re: **Geotechnical Response to Peer Review Comments**
 Proposed High-Rise Building
 1040 Somerset Street West - Ottawa

file: PG2674-MEMO.09

Paterson Group Inc. (Paterson) prepared the current memo to provide our responses to the geotechnical peer review comments in the letter entitled “Peer-Review of Geotechnical Report and Shoring Plans” prepared by DST Consulting Engineers Inc. (DST) and dated June 14, 2021. This memo should be read in conjunction with the current Geotechnical Investigation Report (Paterson Group Report PG2674-2 Revision 3 dated August 12, 2021).

Figure 4 - Section A - Existing Conditions - Static Analysis

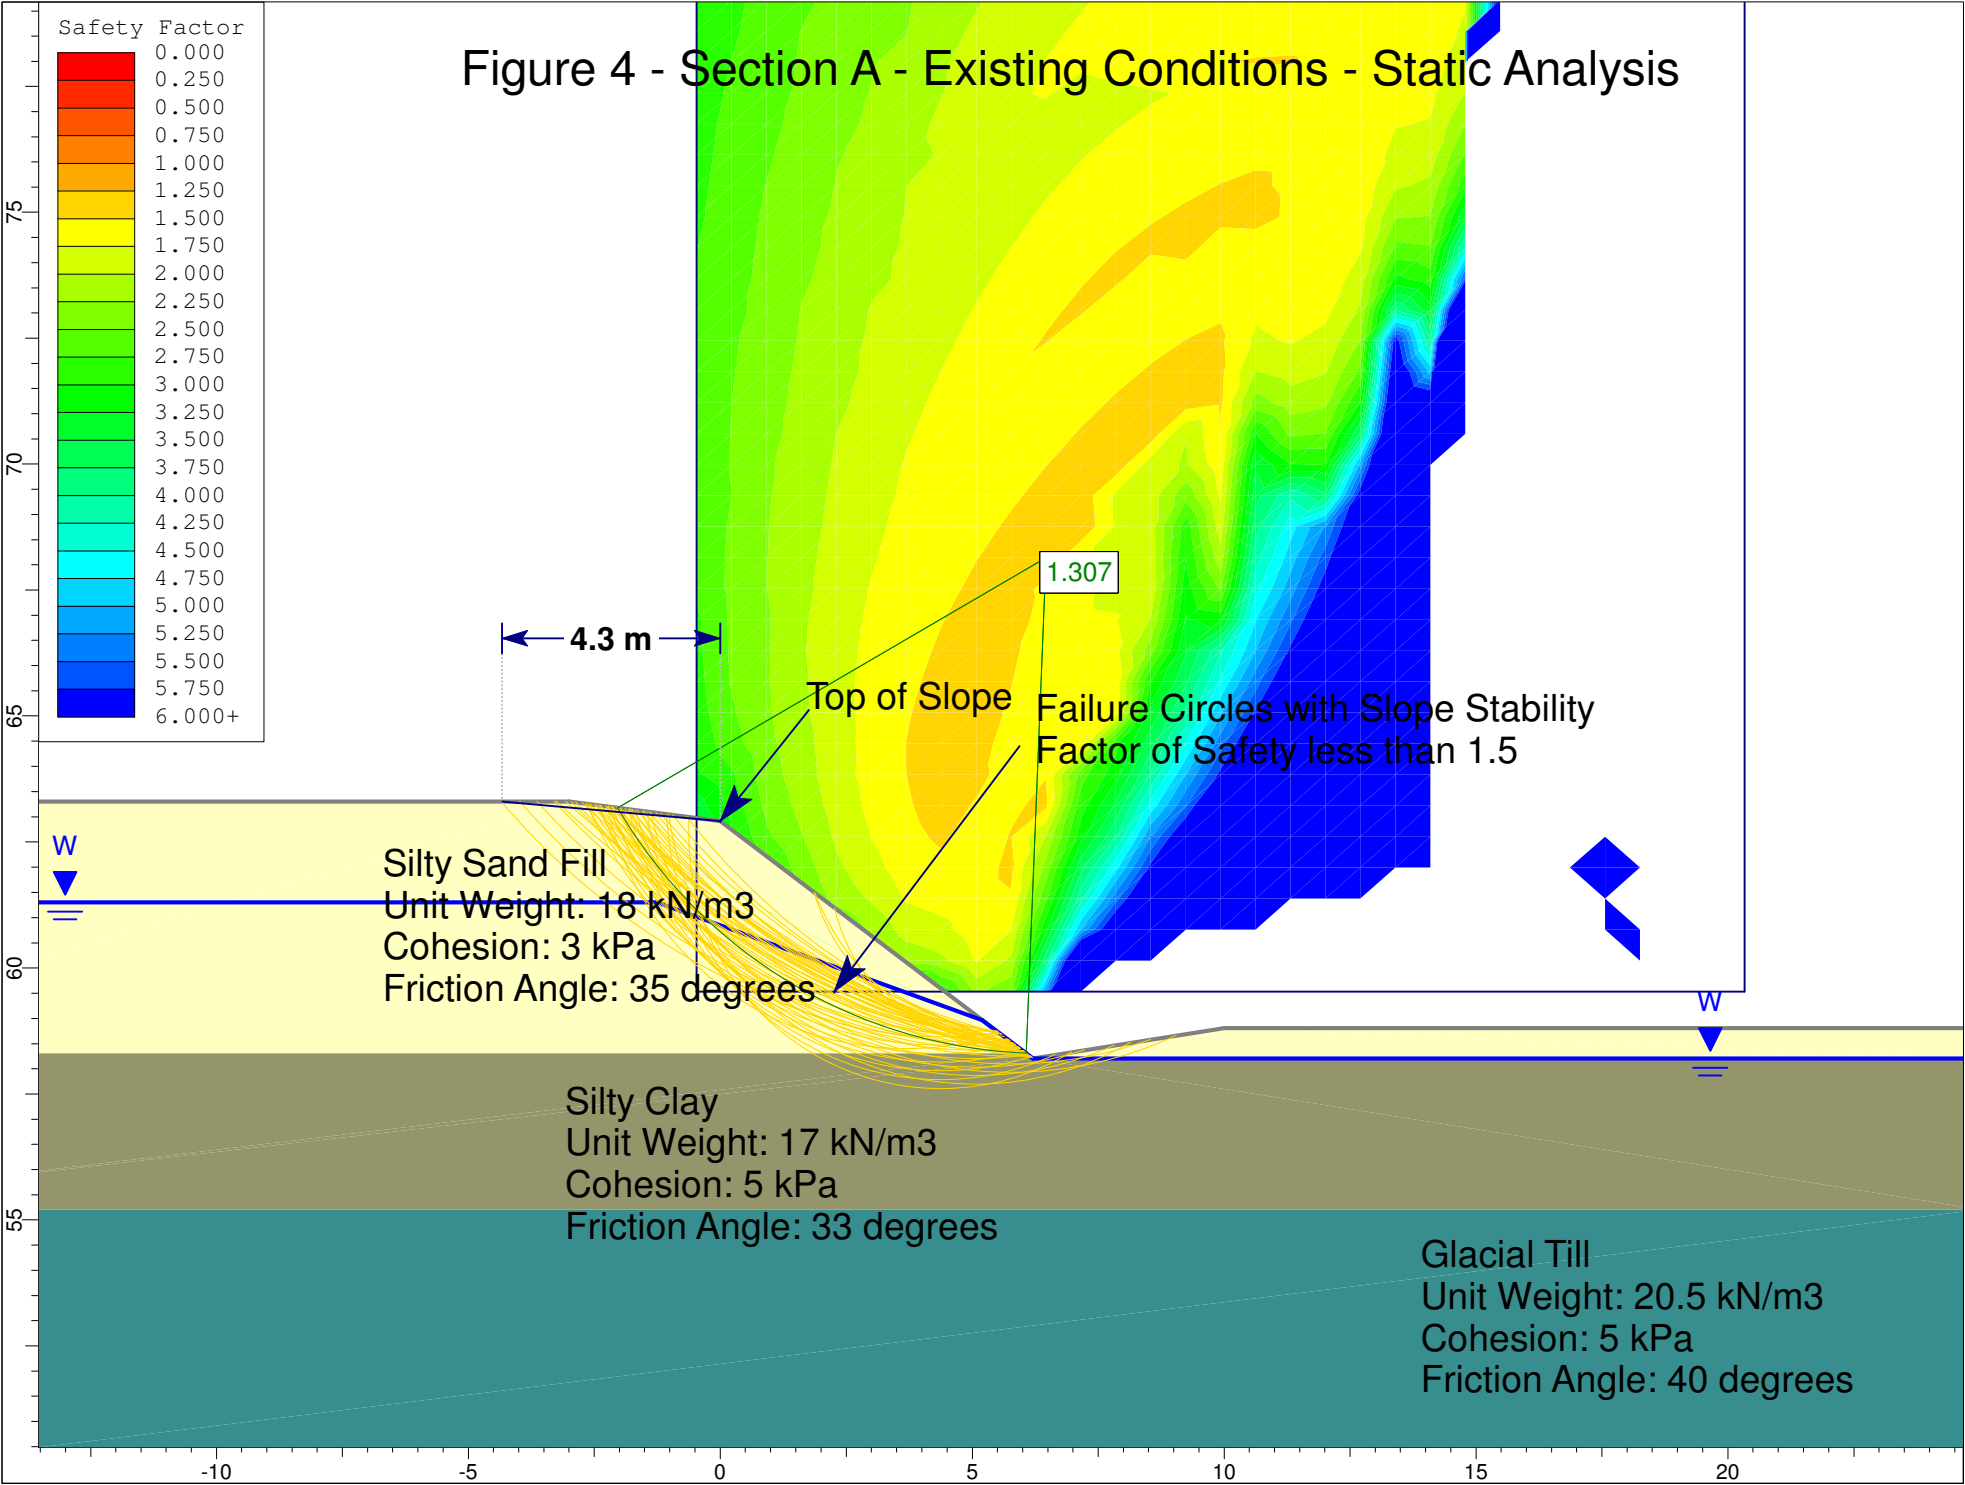
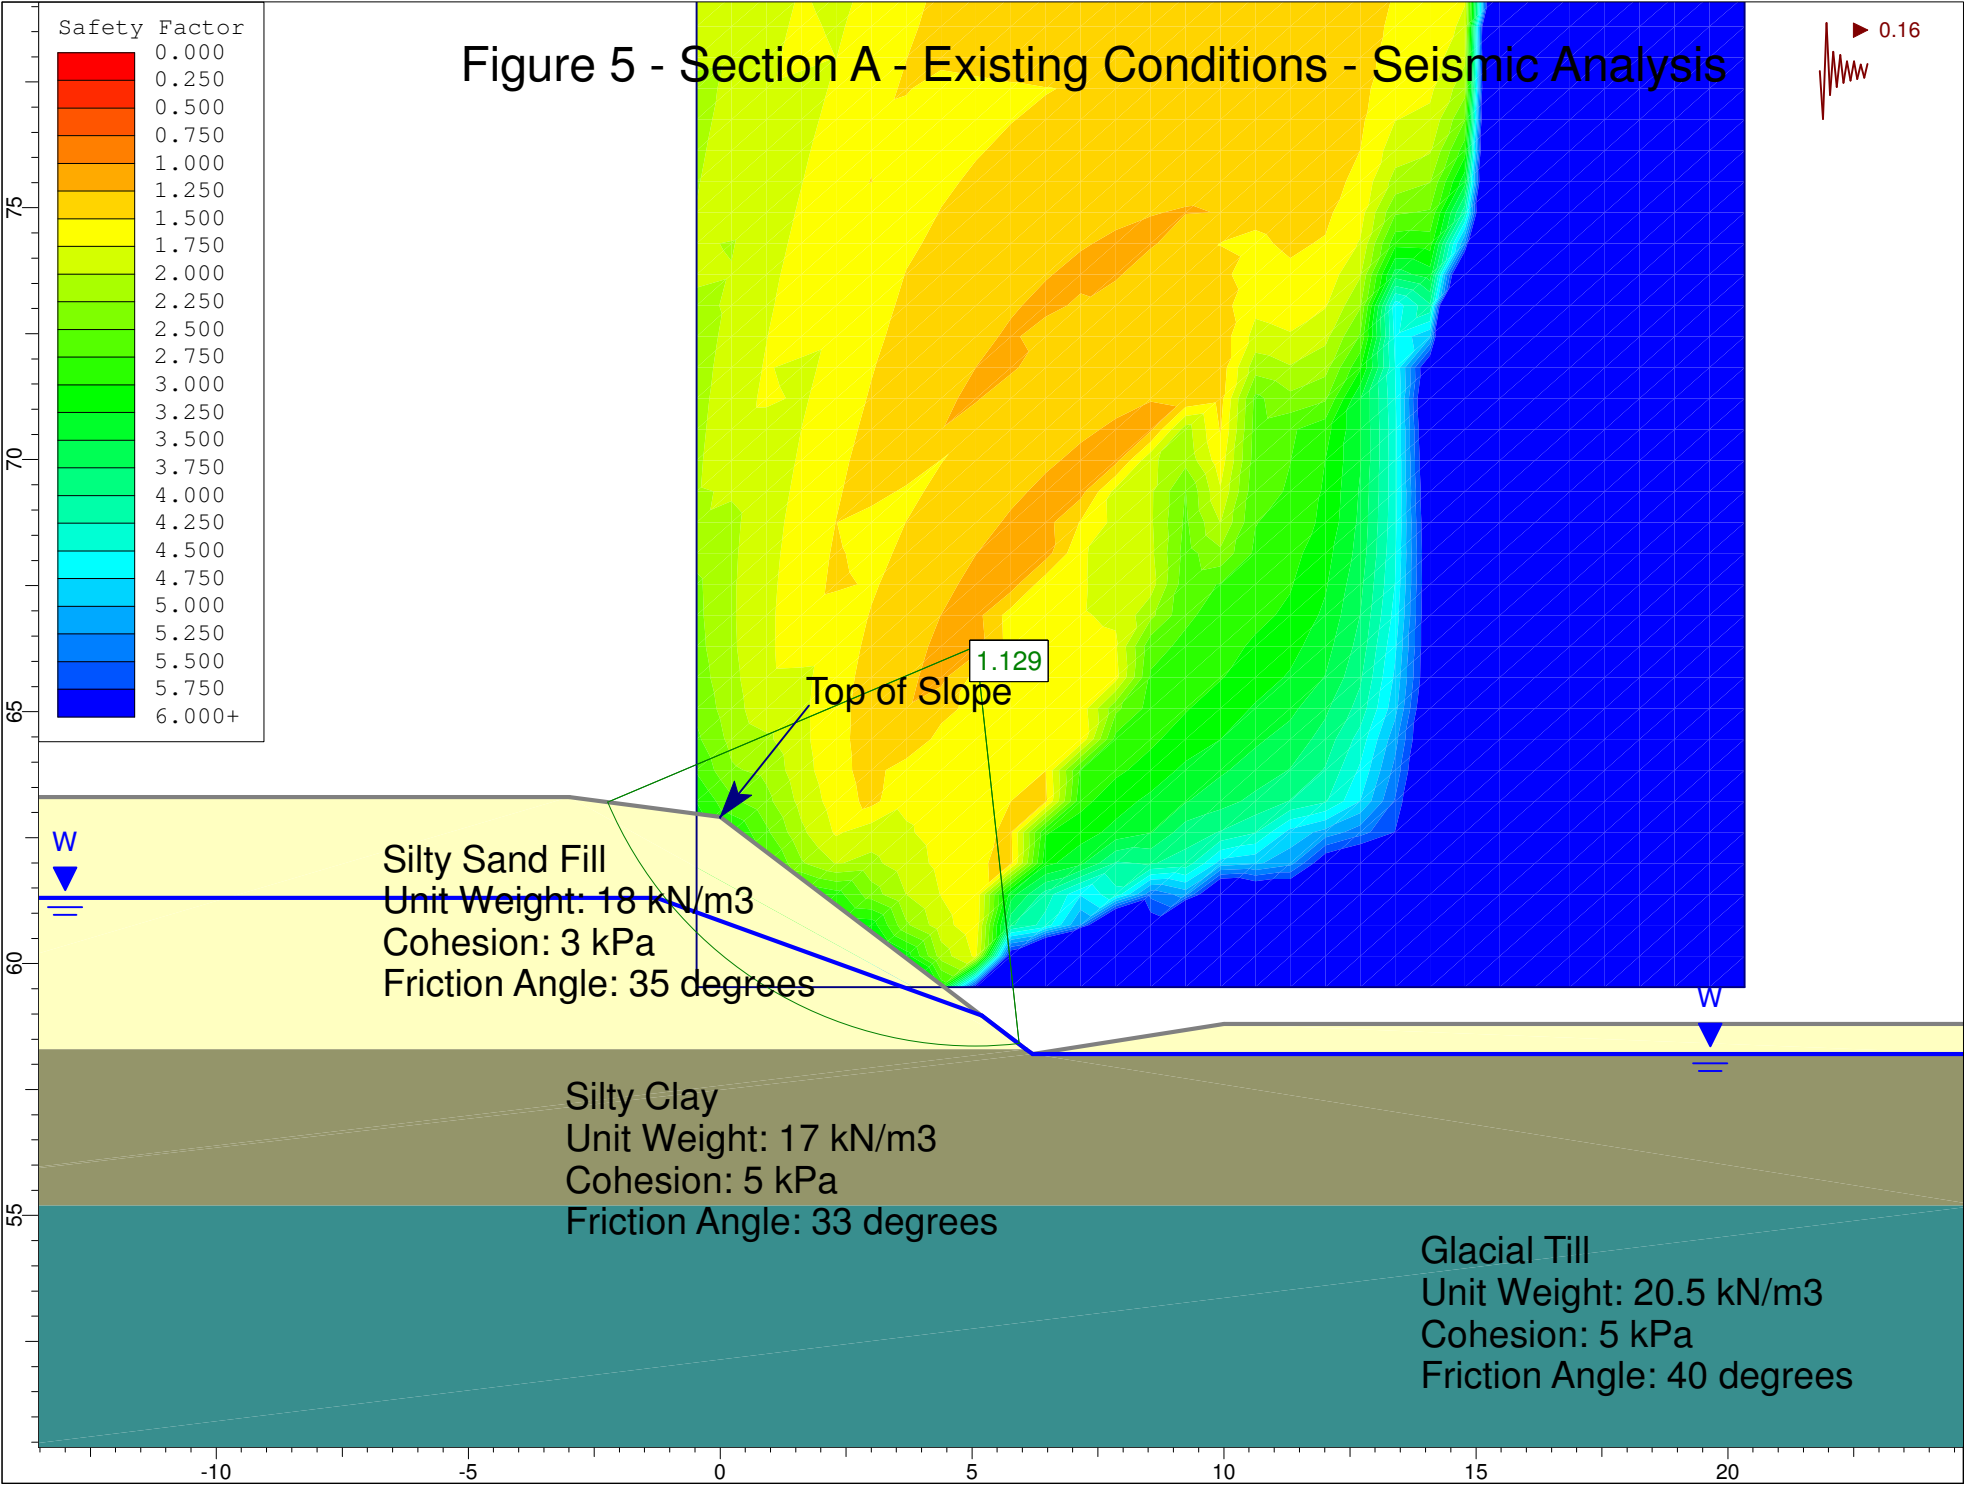
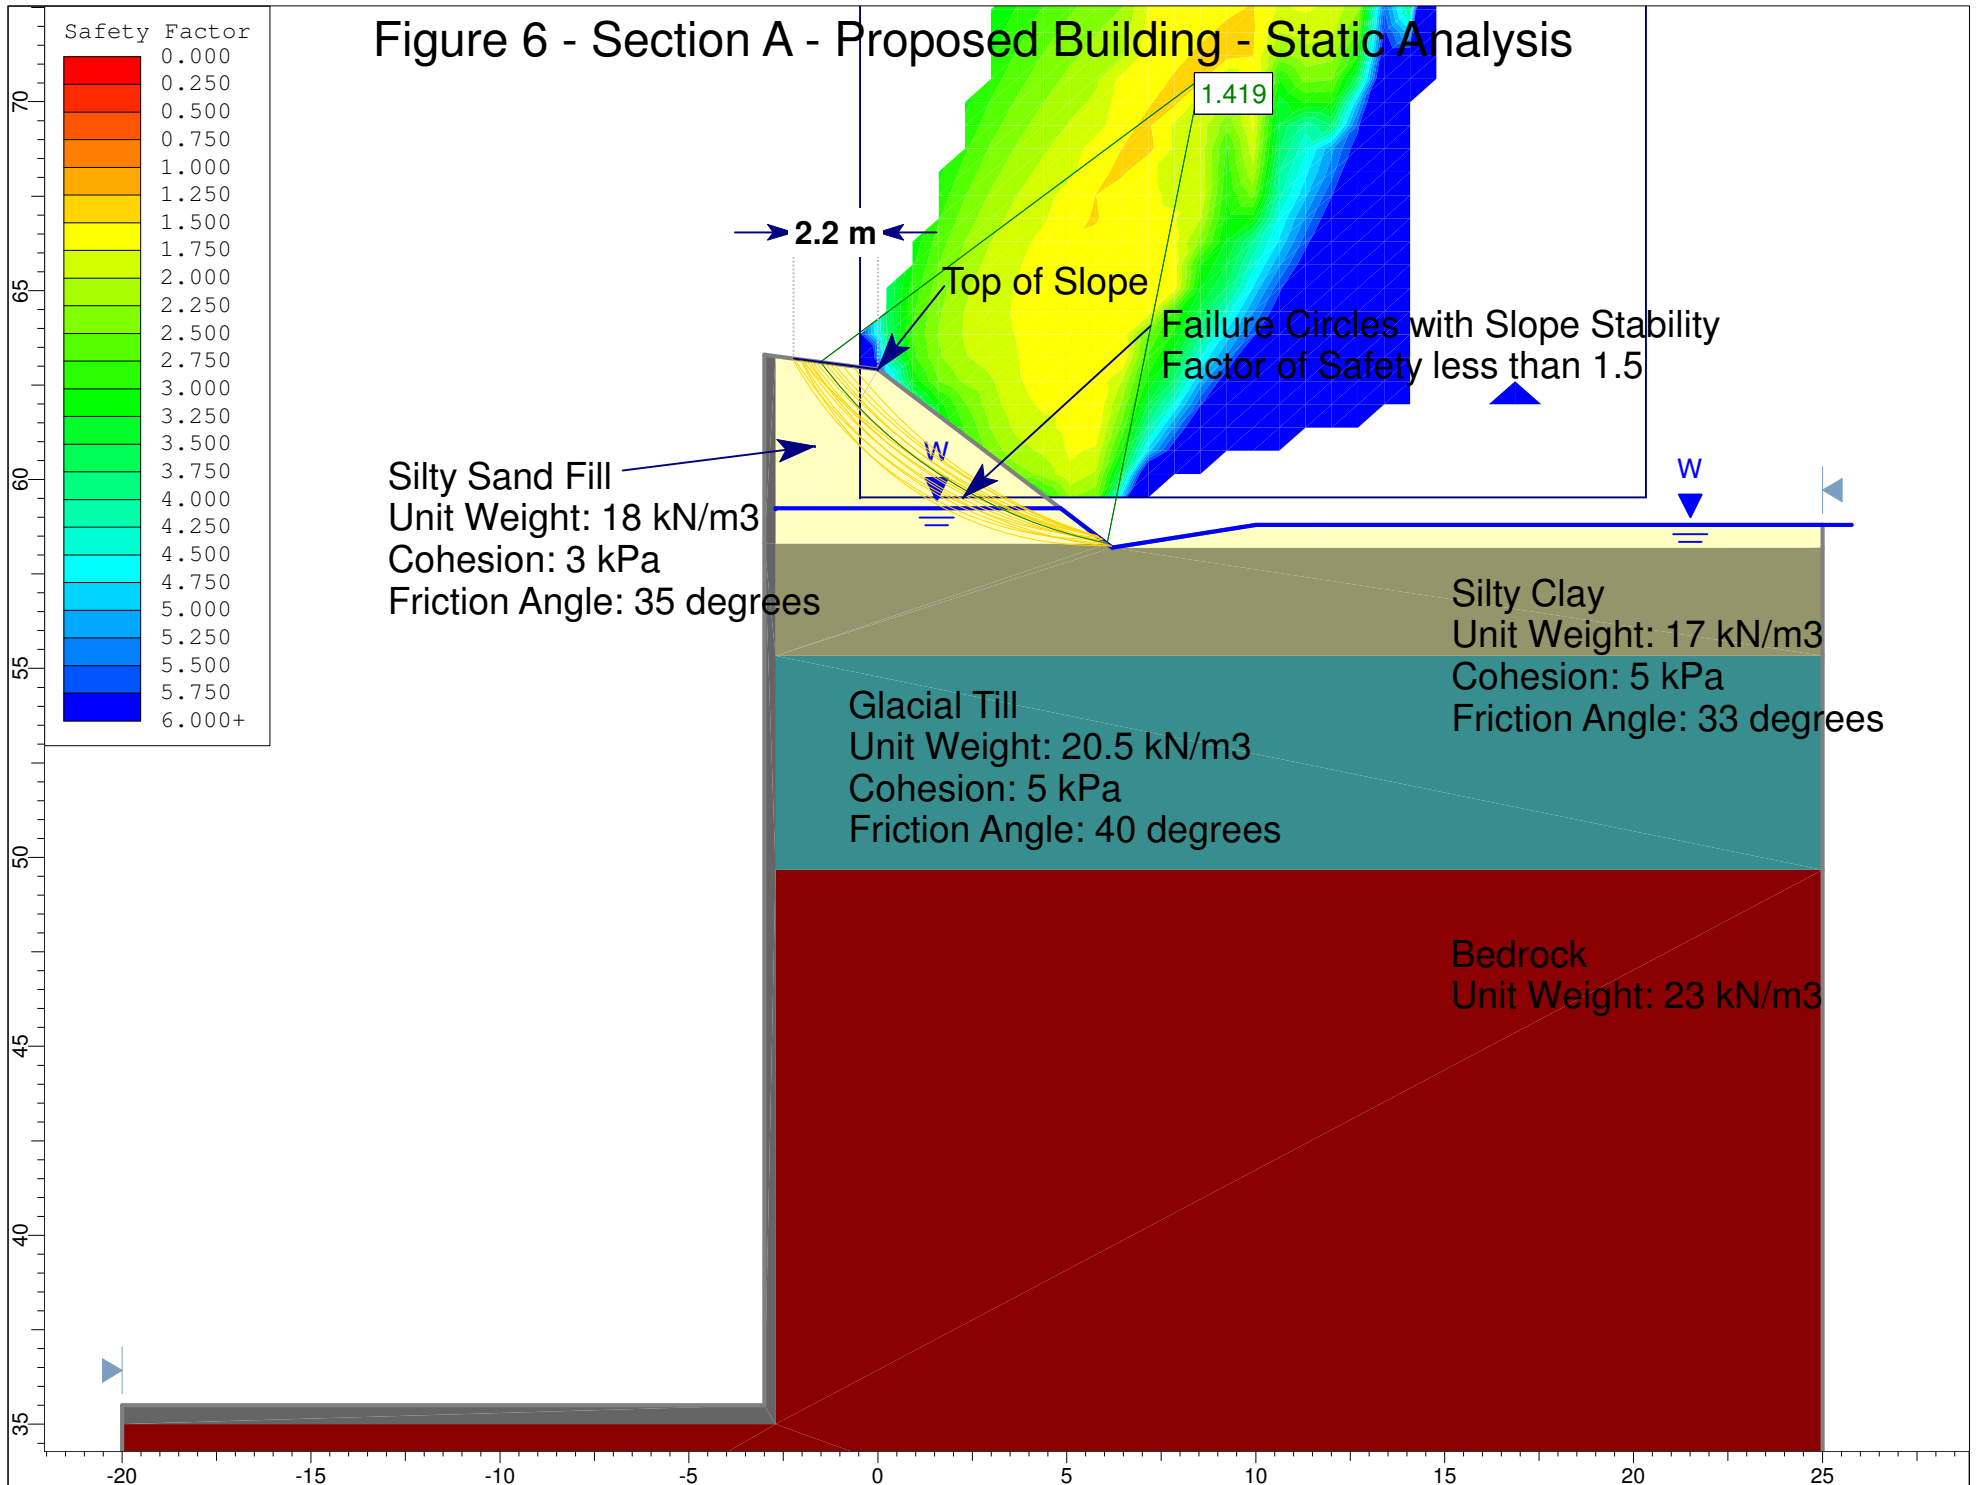
Comment 5: *The report includes slope stability evaluations under both static and seismic conditions for the west slope of the O-Train corridor indicating only a marginal safety factor against potential instability under the static condition. More detailed evaluation of the impact of the proposed construction methodology such as proposed dewatering, installation of sheet piles and tie backs, and equipment travel or operation on the stability of the existing and proposed slopes is therefore recommended.*

Response: For the permanent condition, once construction has been completed, the proposed development will not induce new loads on the existing slope, as the new walkway along the eastern boundary of the site will be cantilevered over the slope.

For the temporary condition during construction, dewatering is not expected due to the use of steel sheet piles as the temporary shoring system along the east side of the excavation. However, even in the event that some dewatering was to occur during the construction period, this would only act to improve the factor of safety of the slope.

Other construction activities such as sheet pile installations, tieback installations, and equipment travel are not expected to negatively affect the existing slope stability.
